LAND AND LAKES PROPOSALS AT HOLYHEAD APPLICATION REF: 46C427K/TR/EIA/ECON

In addition to the information provided in these submissions, Land & Lakes is proposing revisions to the development at Kingsland which further improve the situation. The enclosed revised Kingsland Land Use Parameter Plan (Ref. PL1114.K.PP101 rev C) clearly shows the revised parameters for development proposed by Land & Lakes and the location of areas 1,1A & 2 described below.

Figure 5.3 Kingsland Indicative Masterplan

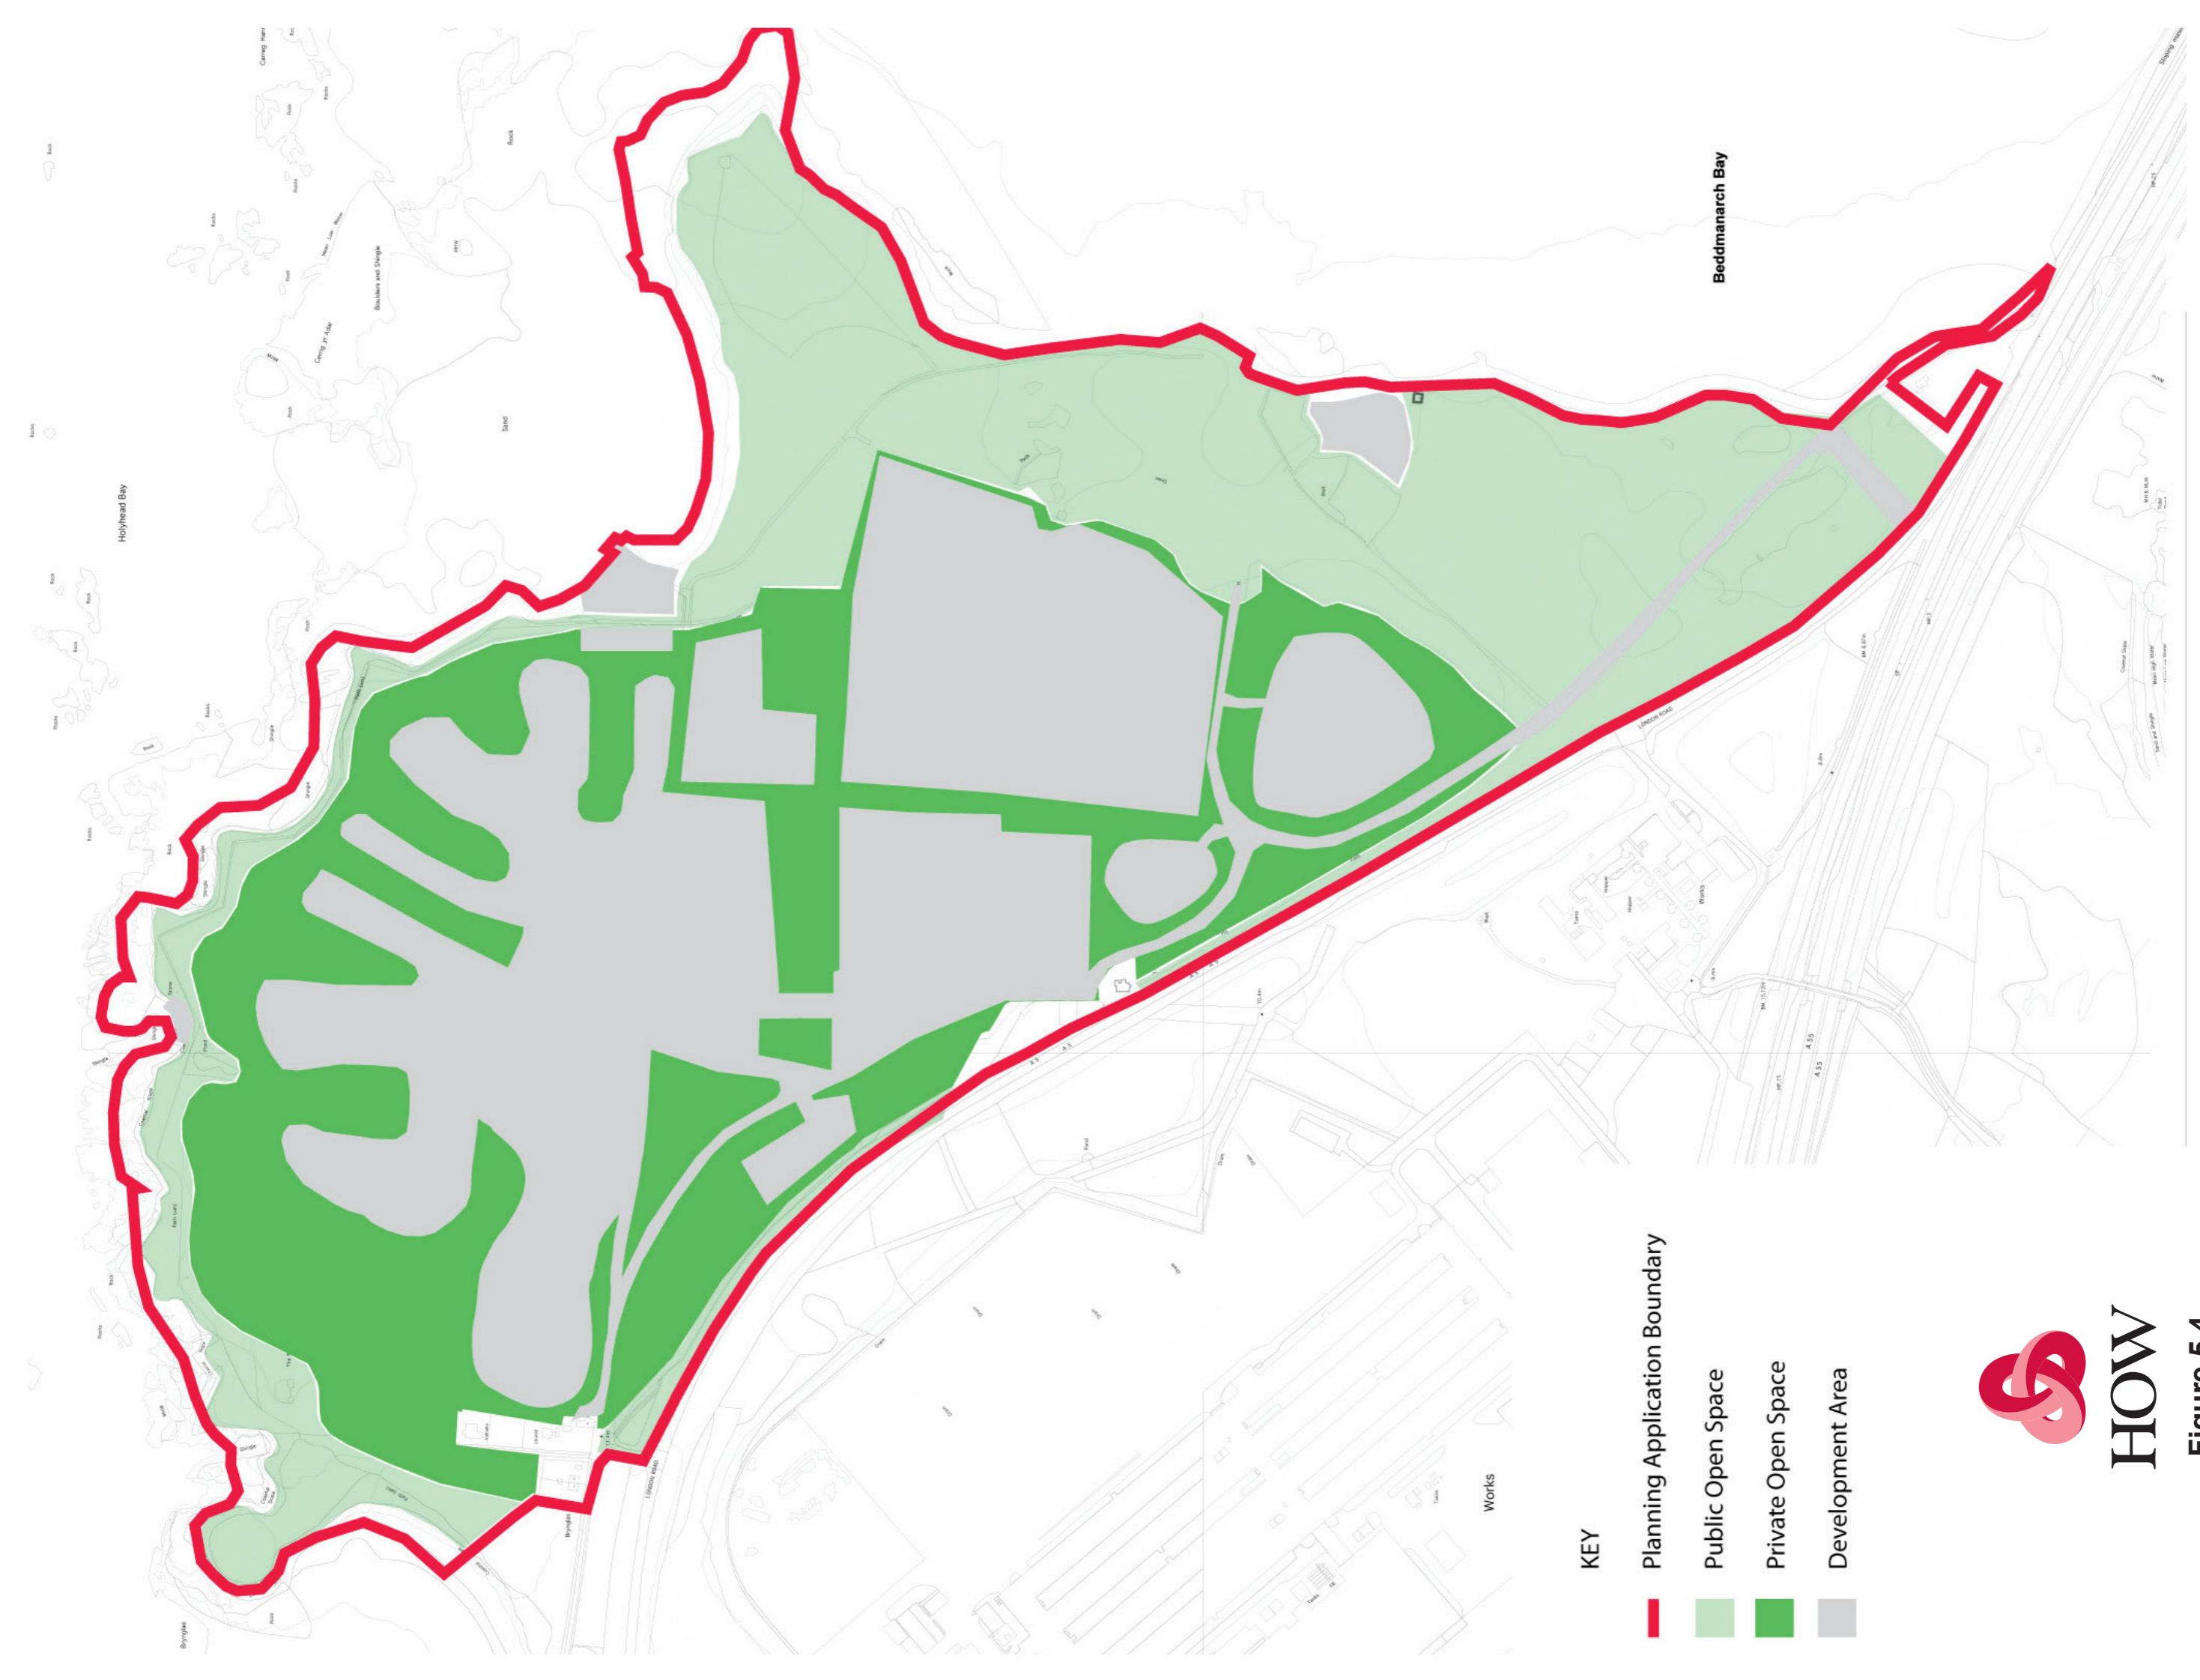
Land & Lakes has given considerable consideration as to whether these areas can be omitted from the proposed developable area. It is possible to omit area 2 but not possible to omit area 1 (as referenced on the attached plan). However, to compensate for this, a larger area of land (referenced as area 1A), which is located within Holyhead's settlement boundary, is proposed to be omitted. The omission of this land provides an increased buffer between the proposed built development and the open countryside to the west, from where there are views over the site (as shown in the submitted Landscape and Visual Assessment). This would serve to further reduce the landscape and visual

impact of the Kingsland proposals upon the AONB. This added benefit would not be achieved by omitting area 1 as views into this area are over the golf course, which comprises higher land that naturally screens this part of the site.

In total, the developable area will be decreased by 1.034 hectares and to reflect this, the revised number of houses proposed at Kingsland will be reduced to a maximum of 320 (down from 360). This reduction in house numbers is the maximum reduction that Land & Lakes is able to offer and the revision to the proposals reduces the developed area across the entire scheme to approximately 16.5% of the application site.
